City of Albuquerque Stormwater Construction Site Inspection Report

Project Name and Location	O'Reilly Auto parts Comas and Chukwood Park		
Site Contact Name & Agency	George Shiden O'Reilly Auto parts	Contact Phone #/ E-mail	Sjennings@ oreillyauto.com
Date of Inspection	10-11-16	Start/End Time	1:50/2:05
Inspector Name, COA Dept.	Curtis Cherne, Stormwater Quality		
Inspector Phone / E-mail	505-924-3420/ccherne@cabq.gov		
Inspector Qualifications	Qualified Compliance Inspector of Stormwater- Stormwater One		
Describe Present Phase of Construction	Stabilized

From: Cherne, Curtis
Sent: Wednesday, May 04, 2016 10:55 AM
To: sjennings@oreillyauto.com; 'grobertson@gmnorthrop.com'
Subject: O'Reilly's AUto Parts 12700 Lomas follow-up SWPPP inspection
Attachments: cement_pollution1.JPG; cement_pollution2.jpg; missing_wattle.jpg; trash.jpg; sediment_street_sidewalk.jpg

PROJECT:
NEW O'REILLY AUTO PARTS STORE
12700 LOMAS BLVD NE
ALBUQUERQUE, NM 87123
STORMWATER POLLUTION PREVENTION PLAN

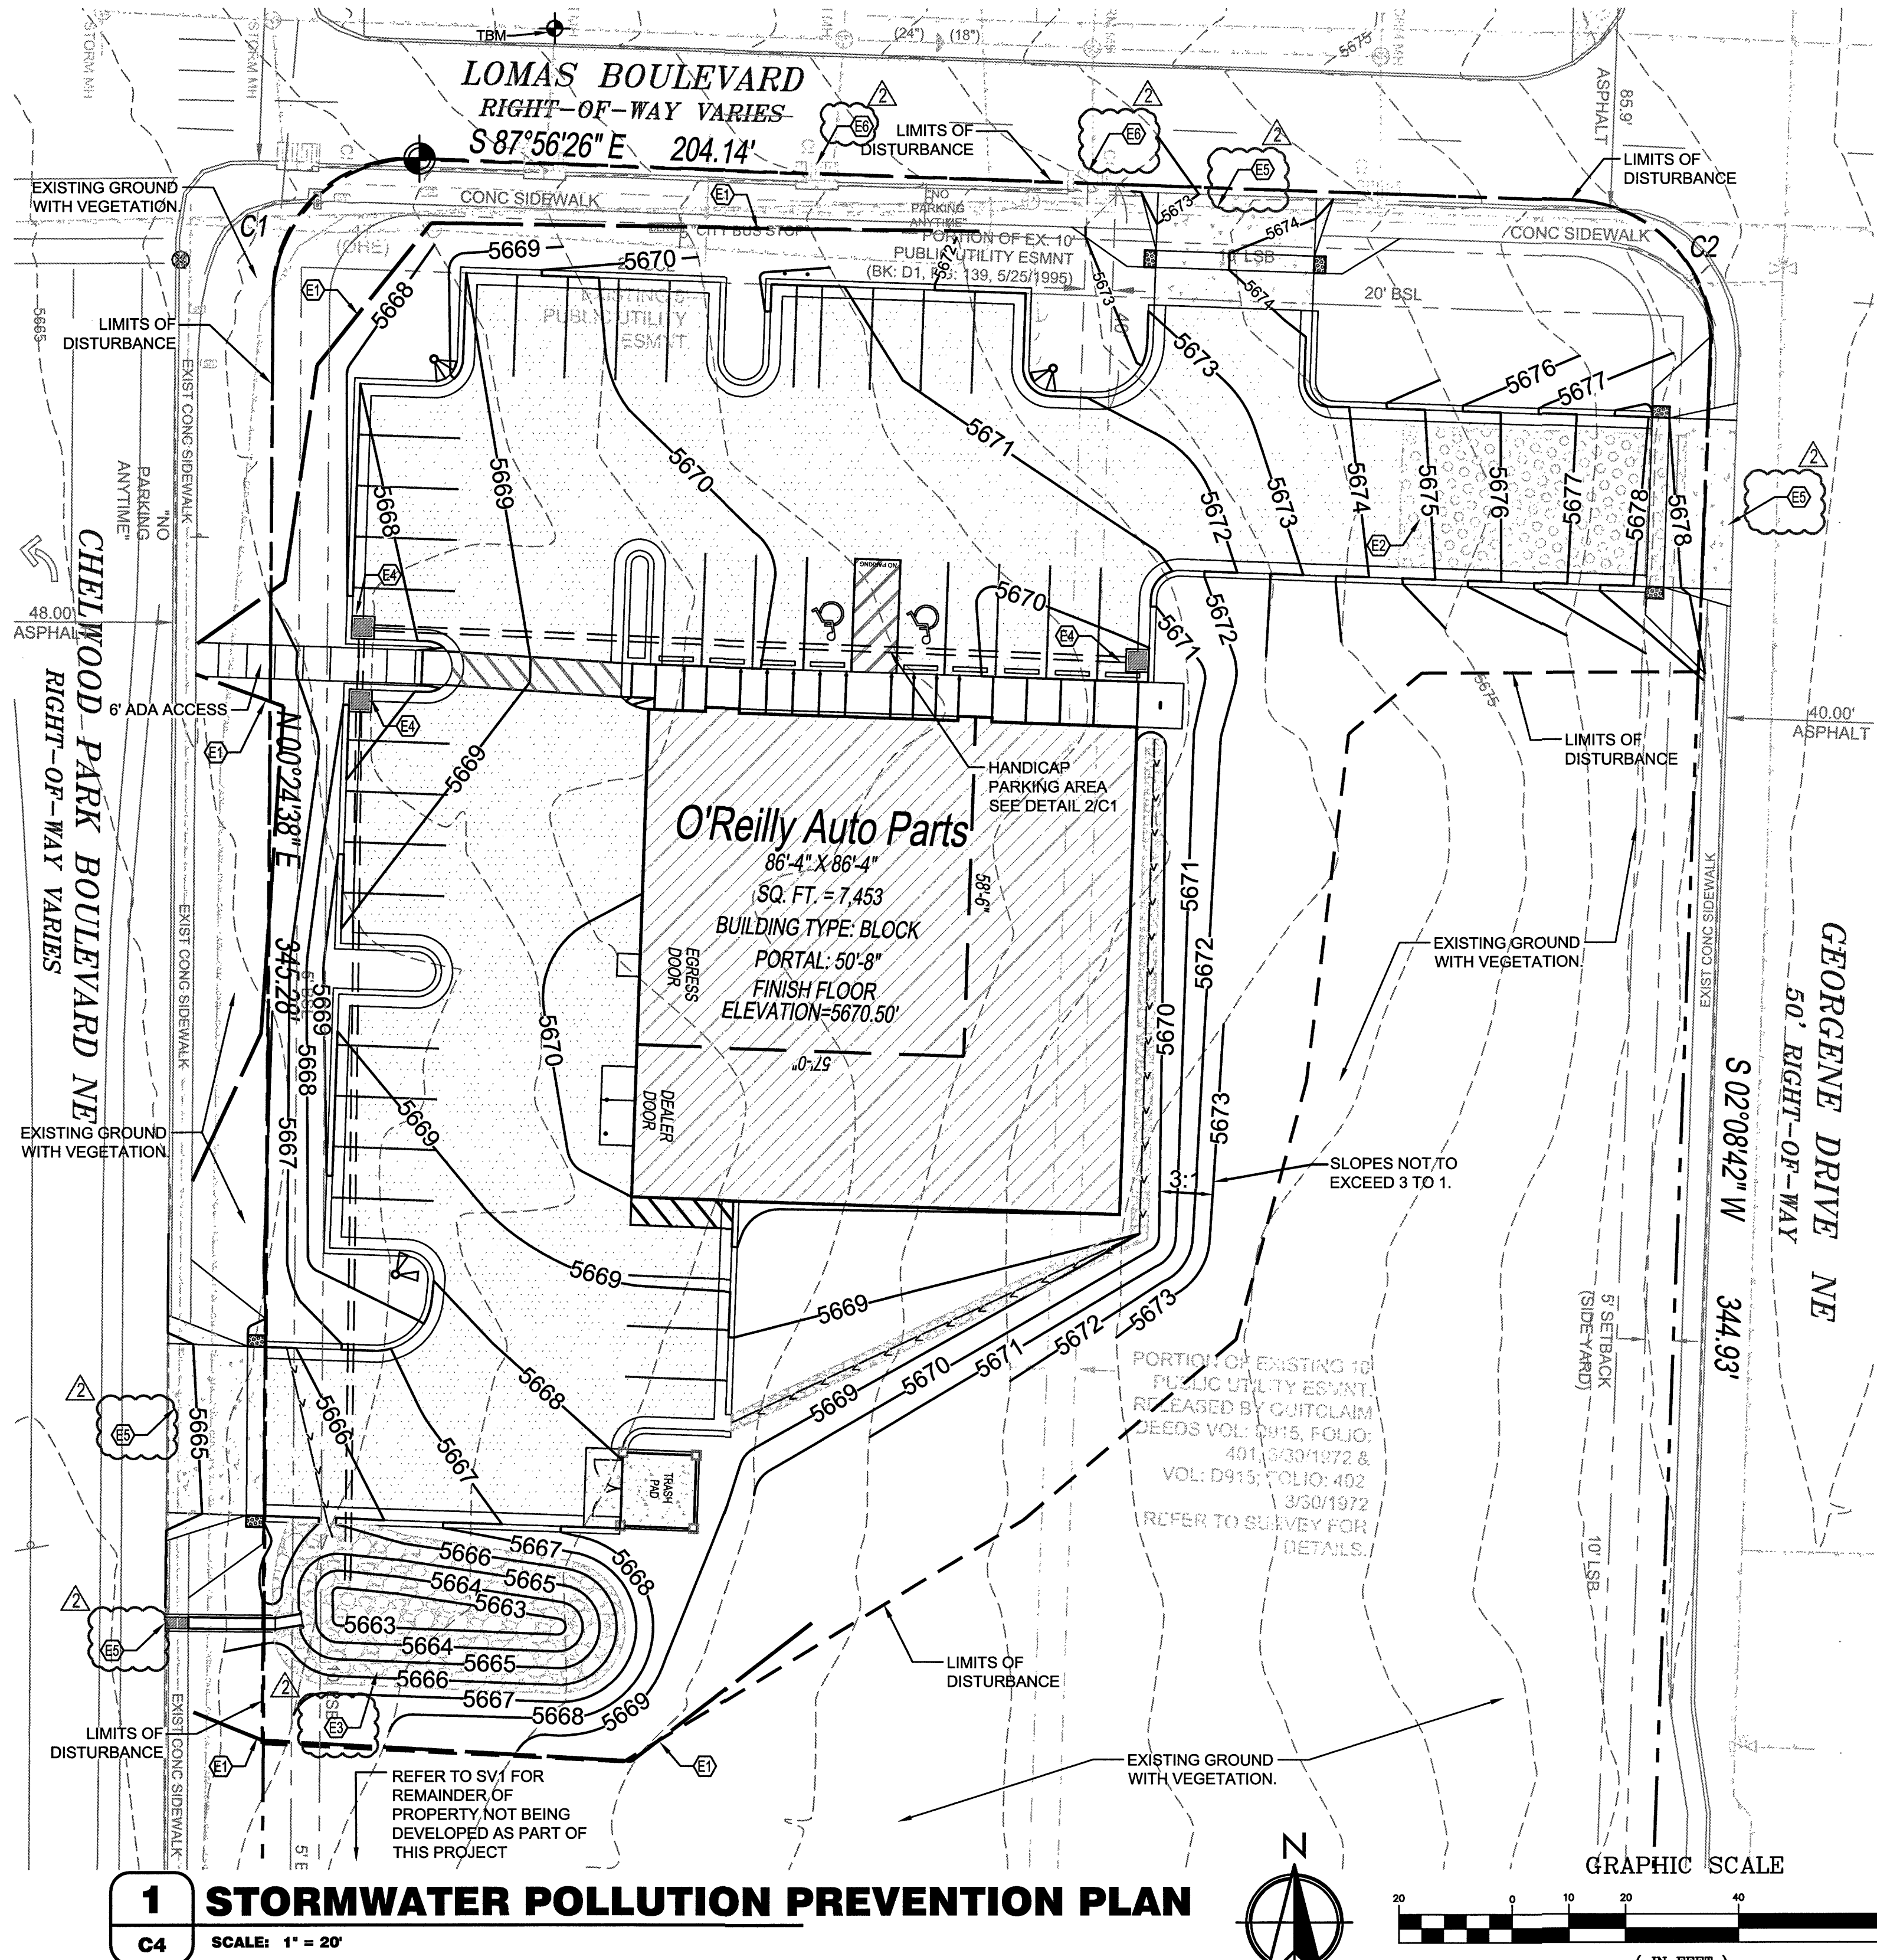
1. No stabilized entrance. Track-out was minor.
2. Trucks leaving the site at an egress not identified on ESC plan. Gene said he would close.
3. No SWPPP on site.
4. Site not posted per paragraph 1.5 of the CGP.

Curtis,
We will get these items taken care of, can you tell me which project this is for?
